CITY OF ALBUQUERQUE

**RE: NMAC Building (Gym/Volleyball Courts)
Grading and Drainage Plan
Engineer's Stamp Date 1-20-2016 (File:D16D002F)**

Based upon the information provided in your submittal received 2-5-2016, the above referenced Grading and Drainage Plan is approved for Building Permit, with the following condition:

N M A C B U I L D I N G
ALBUQUERQUE • NEW MEXICO
GRADING & DRAINAGE PLAN

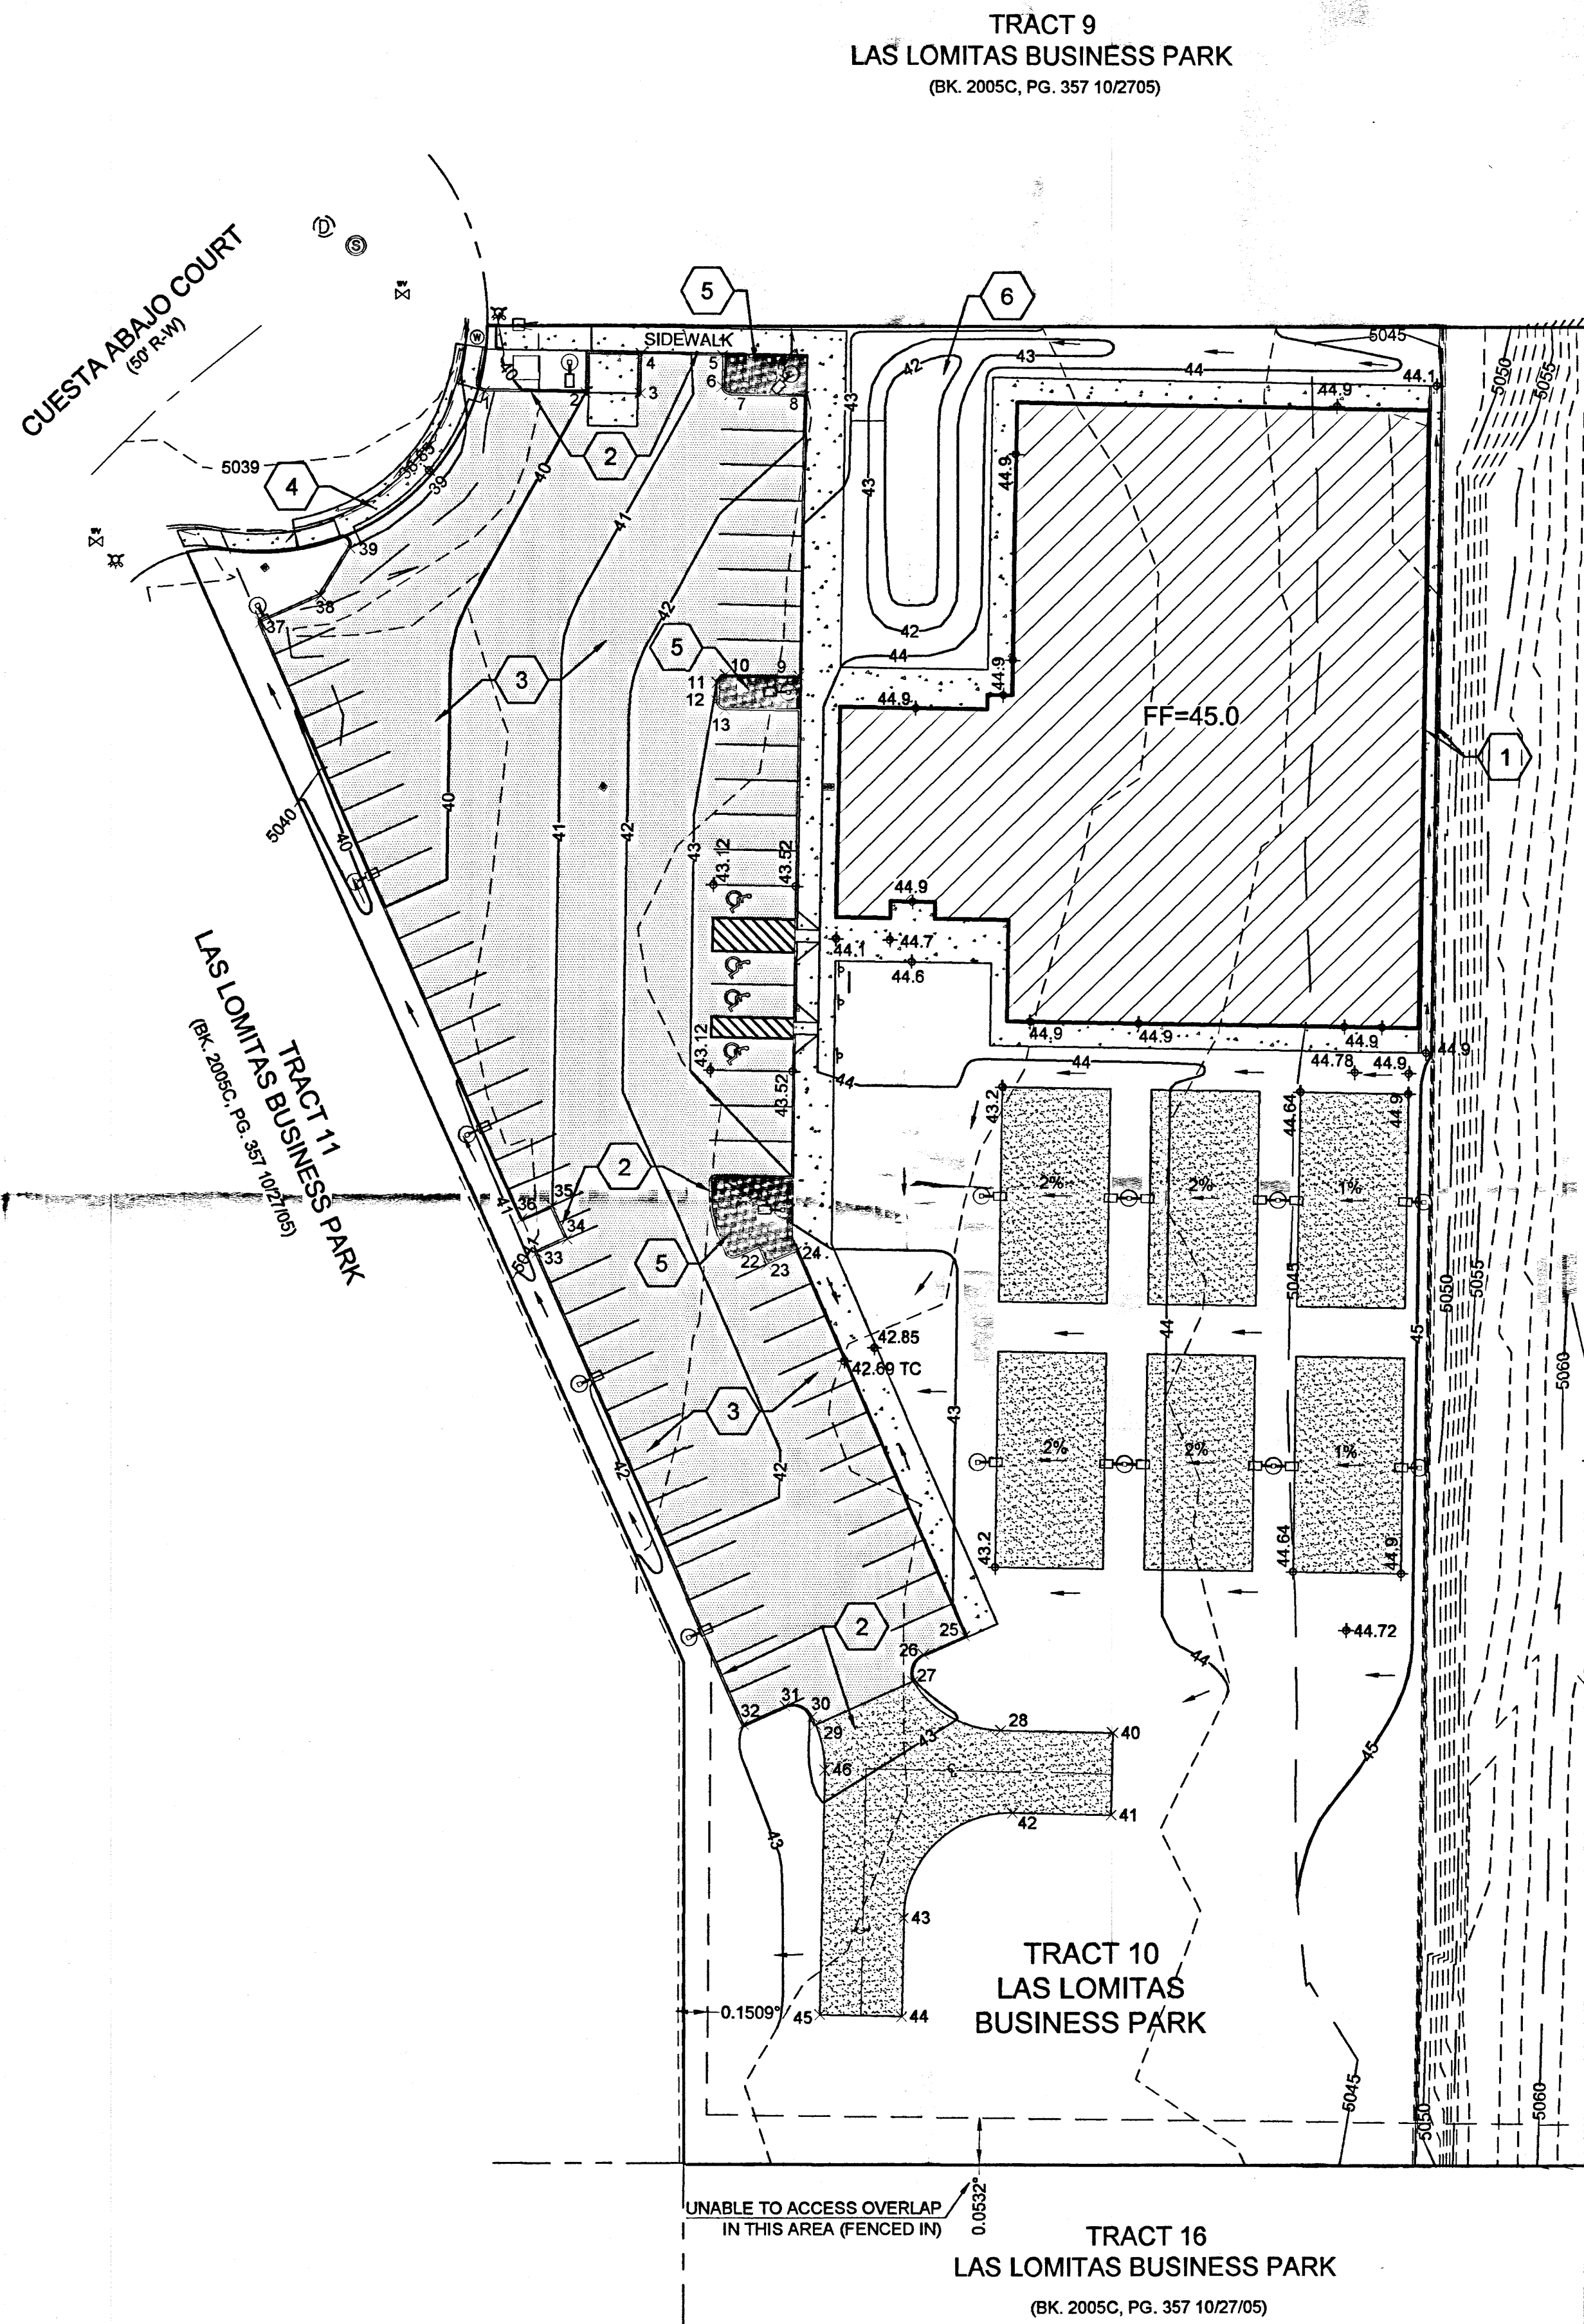
1. Increase the volume of the larger first flush pond to offset the lack of flow expected to get to the three parking lot planters (the parking lot planter depressions can be eliminated). Please show the change on the as-built set when submitting the Certification.
2. Submit an ESC Plan and an ESC Grading Permit prior to any earthwork.
